RFI

RFI #: 42
Date: 1/26/2012
Job: EB-02 Keller Springs Lofts
Phone: 877-777-5115

Subject: Elevation conflict B2 all 3 unit

SHEET NUMBER
3.2F
BLDG PLAN 'F'

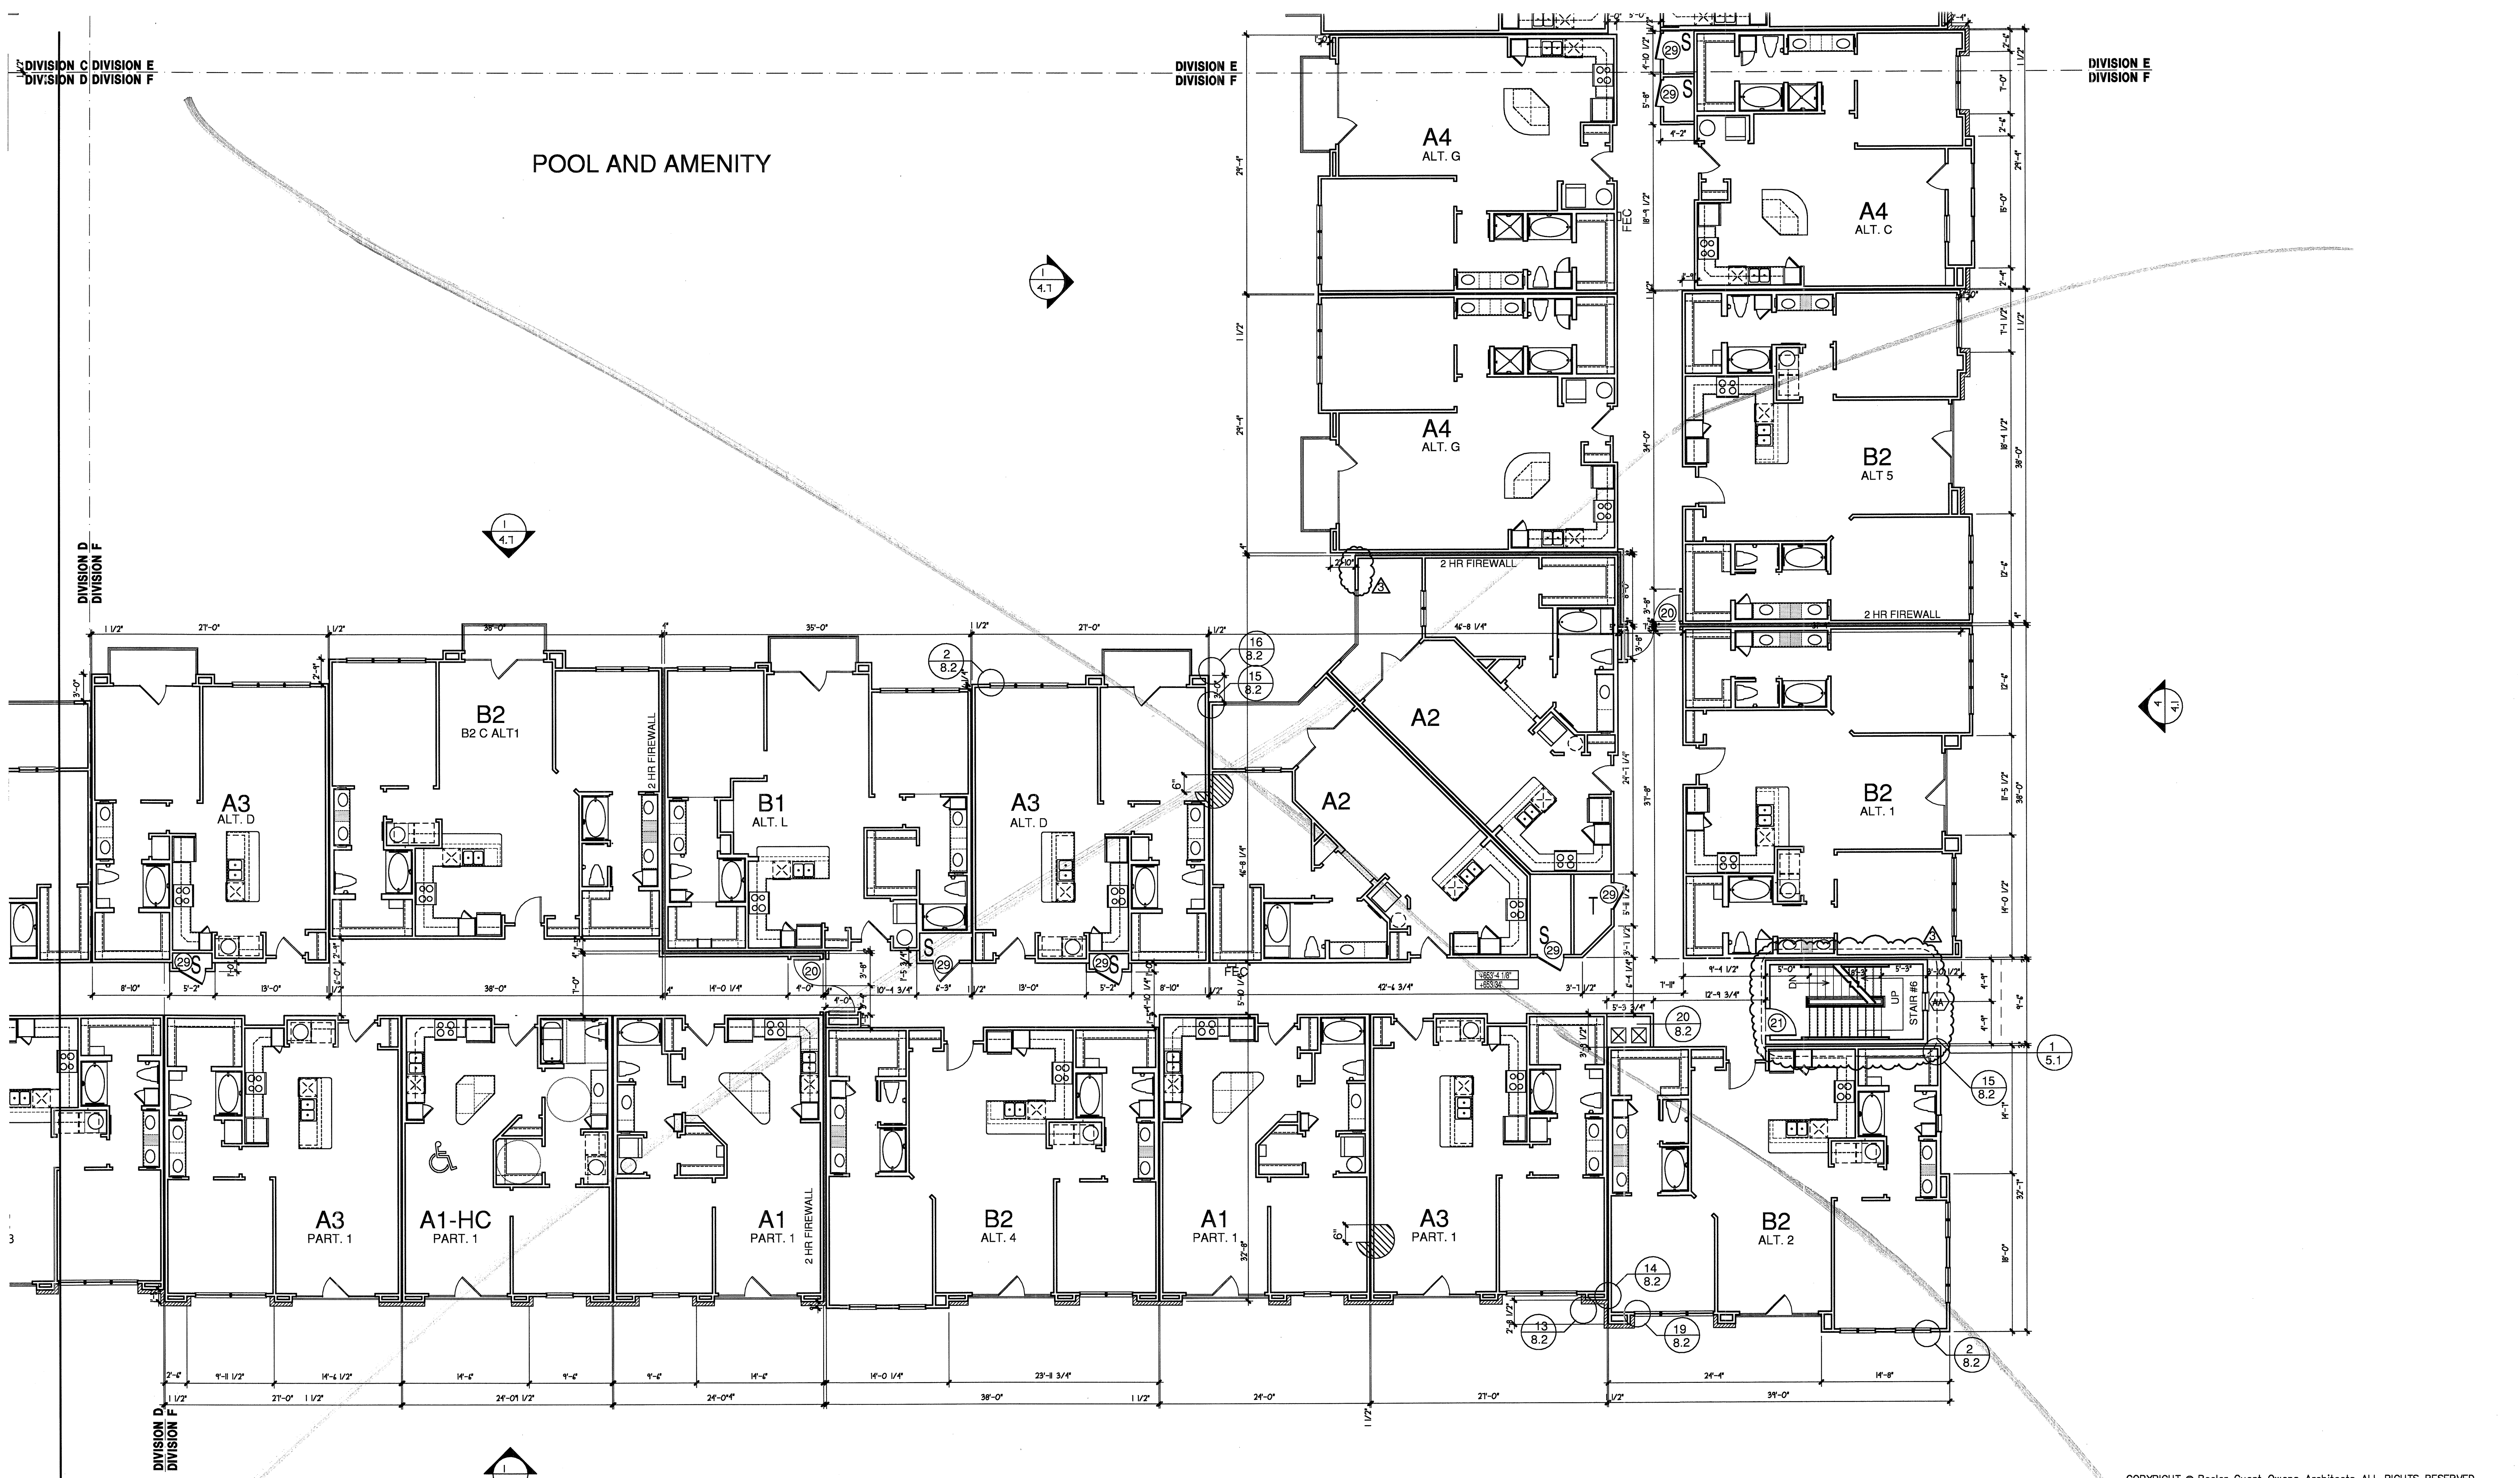
Request: Date Required: 2/2/2012
On sheet 3.2D the B2 all 3 unit on the 2nd, 3rd, and 4th floors are all marked with a H. Sheet 4.1 these unit's windows are drawn as (2) E marked windows, this also happens in the B2 all F units in division F. Please give direction.

Response to this RFI can be found on RFI- 40.
